Submission Form

Epping to Thornleigh Third Track Proposal. Application number SSI 5132.

Name(s): YICHUN DENG

Figure 5.6 Cross-section and elevation - New Cheltenham Station concourse building
Note: Indicatively added to future design

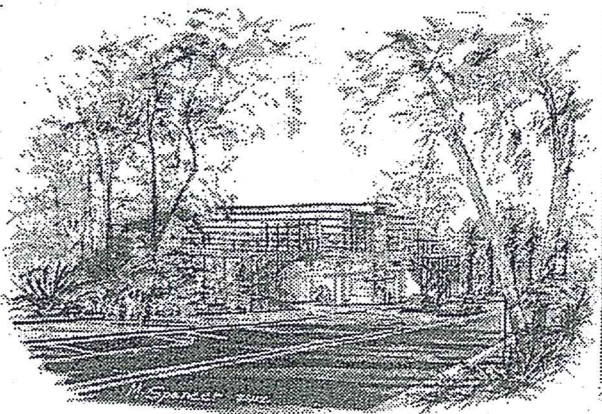
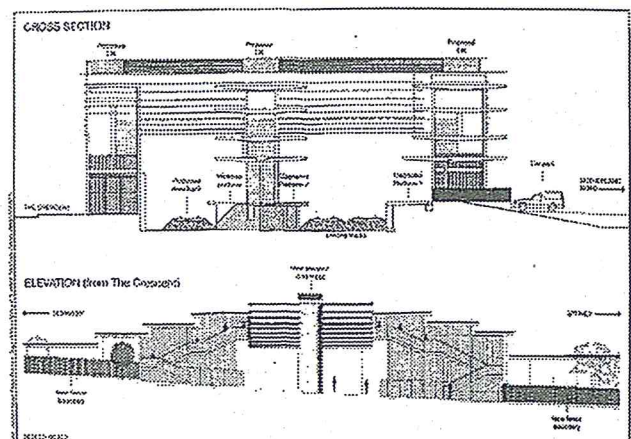
- The proposed redevelopment of Cheltenham Station shows no regard for the HCA. The visual impact of the proposed 13m high glass and steel concourse is totally unacceptable in this HCA.
